**KIRKLEES METROPOLITAN COUNCIL
INVESTMENT & REGENERATION SERVICE**

DELEGATED DECISION TO DETERMINE PLANNING APPLICATIONS

Reference No: 2021/62/90033/W
Site Address: 83, Imperial Road, Edgerton, Huddersfield, HD1 4PG
Description: Erection of two storey side extension
Recommending Officer: Tom Hunt

Officer Report

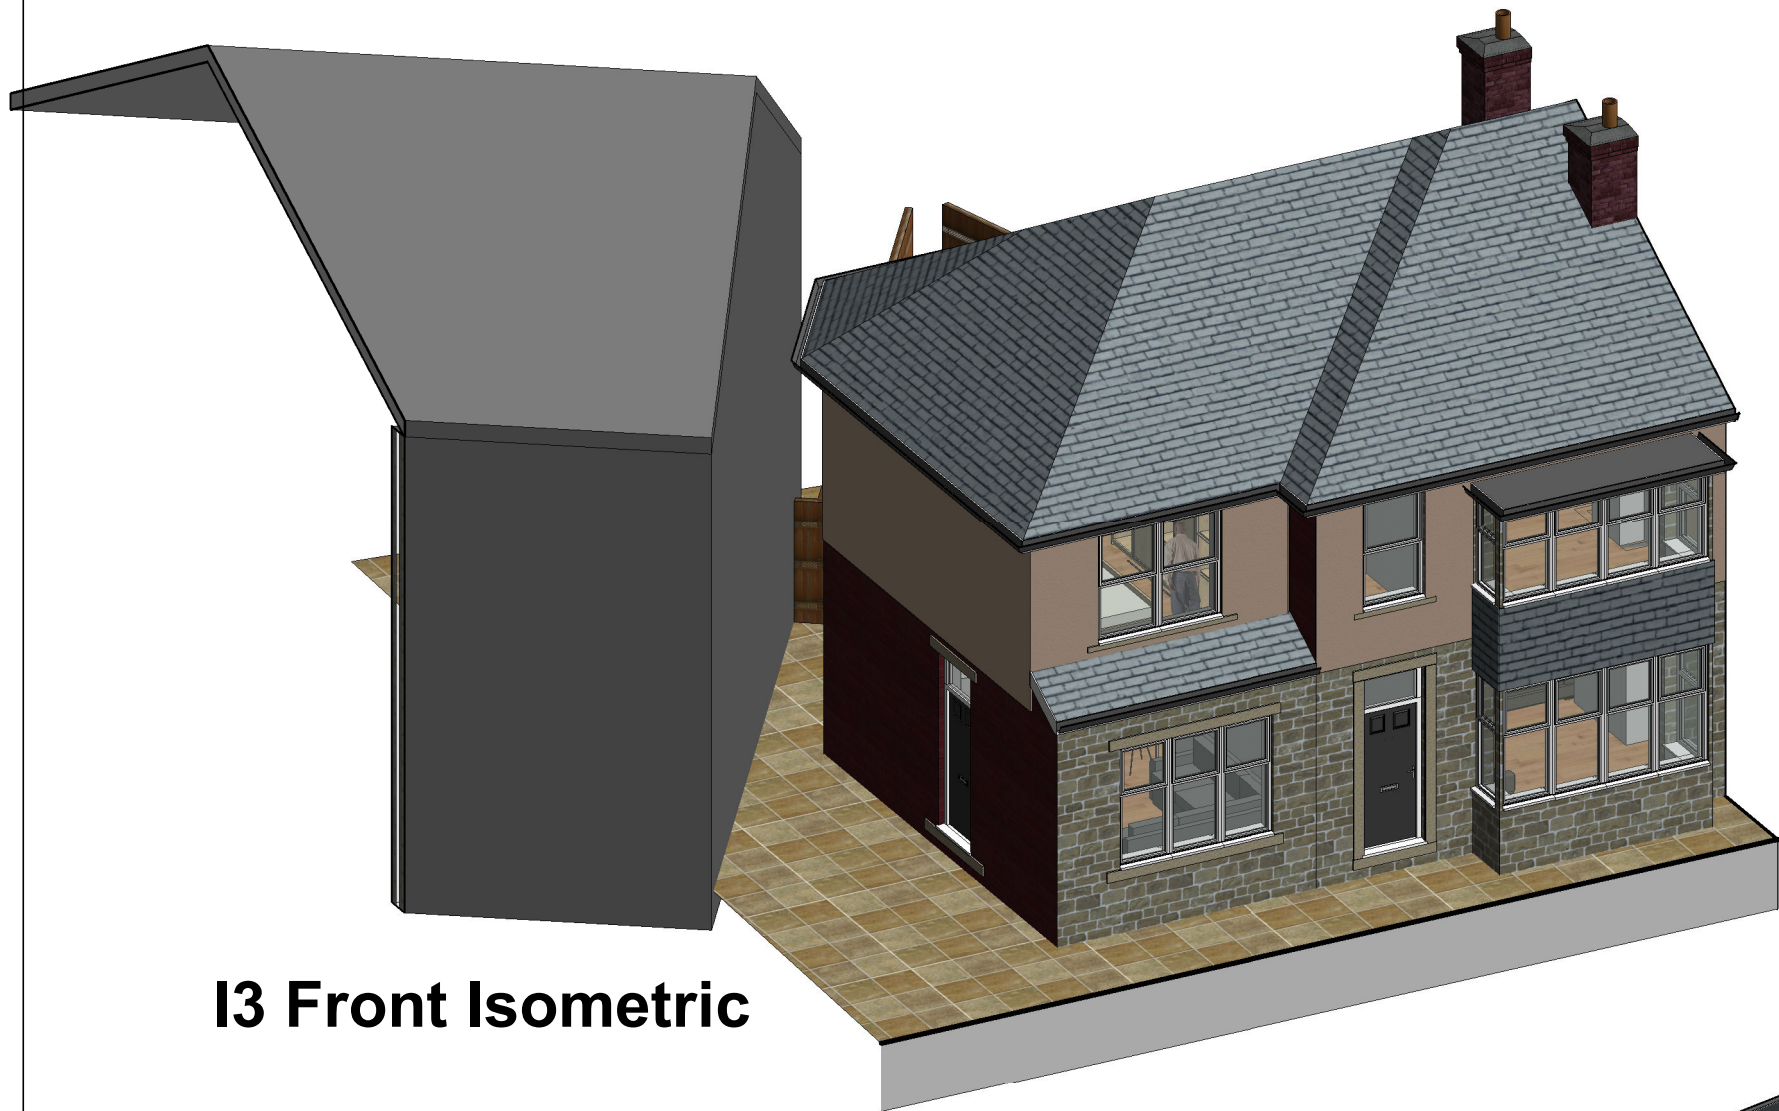
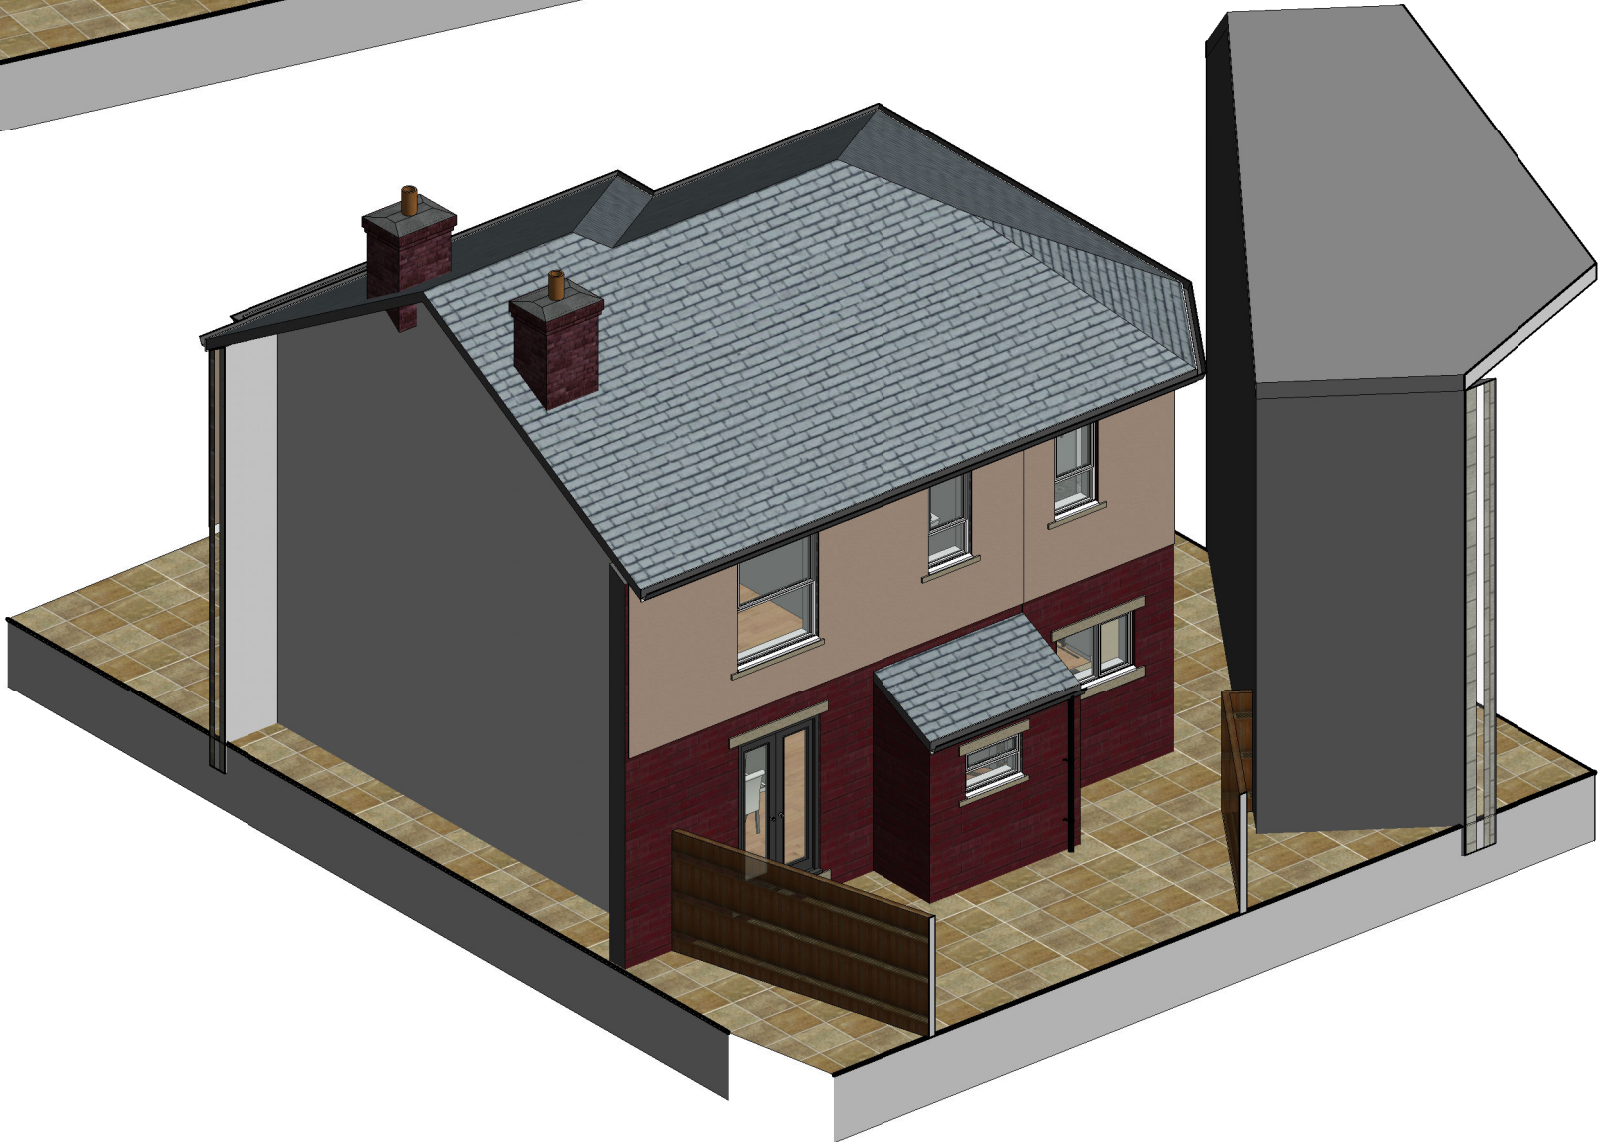
The two storey side extension would be stepped back from the primary elevation at the first storey and set down from the host dwelling aiding in the extension appearing subservient to the main dwelling. At the ground floor the extension would be small in scale with a lean to roof and given the limited projection this is also considered to be subservient.

In terms of the street scene, it is noted that the host dwelling is on a corner plot with its paired neighbour having a side extension of a smaller size. The proposed side extension is larger than the neighbour but the provision of 0.7 metre set back and the setting down of the roof is sufficient to ensure the extension on balance appears as a subservient addition. In terms of terracing the adjacent property is a gable ended property of a differing design and good separation is achieved at the front with a small amount of space to the rear. These arrangements are considered sufficient to prevent any undue impact. The use of matching materials would help the extension to sit comfortably within with the host property and within the wider street scene.

Turning to the impact on the conservation area, the border is to the rear of the site and the position of the extension is not considered to be sensitive to the setting of the Conservation Area. It is noted that the Conservation Officer has advised that the visible appearance of the extension would be improved if it was reduced in scale similar to next door. However, for the reasons set out above the design overall on balance is considered to be acceptable.

3. The external walls and roofing materials of the extension hereby approved shall in all respects match those used in the construction of the existing building.

00 Site Plan - Proposed
1 : 200

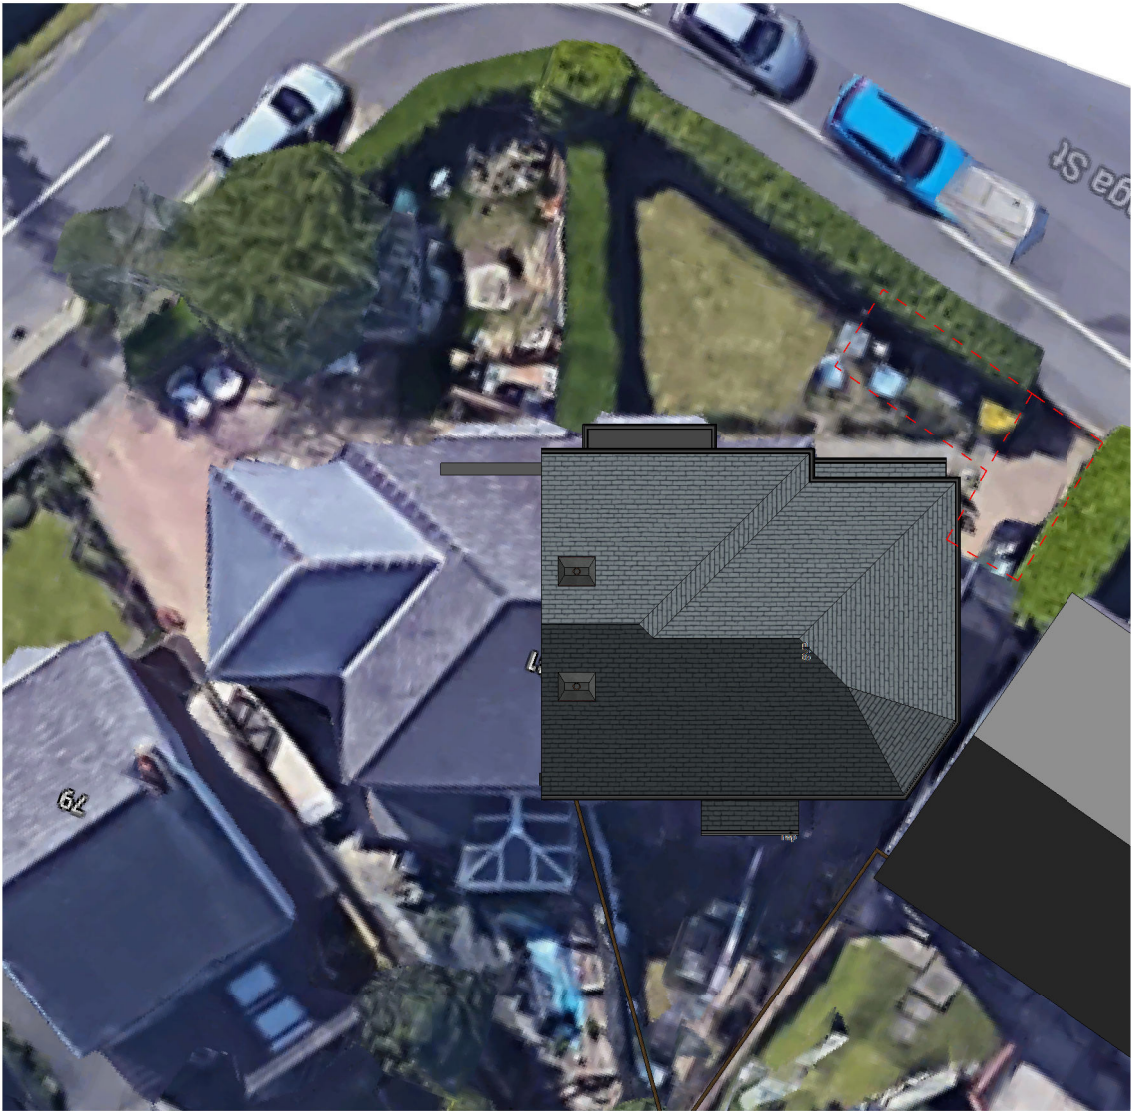
The case officer considered the application on review and requested details of parking arrangements for Highways and feedback from Conservation & Design regarding the design of the extension. The agent submitted the

The proposed development would lead to no.83 having 3 bedrooms and a study and on request, an amended plan has been provided which shows two parking spaces. The provision of the two spaces is consider to be sufficient for the site and will be conditioned to be provided before the extension is brought into use and appropriately surfaced. Subject to the aforementioned condition the proposal would accord with Policy LP21 and LP22 of the Local Plan.

4. The development shall not be brought into use until the areas indicated to be used for parking on the submitted plans have been provided and laid out with a hardened and drained surface in accordance with the Communities and Local Government; and Environment Agencies 'Guidance on the permeable surfacing of front gardens (parking areas)' published 13th May 2009 (ISBN 9781409804864) as amended or any successor guidance. Notwithstanding the provisions of the Town and Country Planning (General Permitted Development) Order 2015 as amended (or any Order revoking or re-enacting that Order) these areas shall be so retained, free of obstructions and available for the uses specified on the submitted plans.
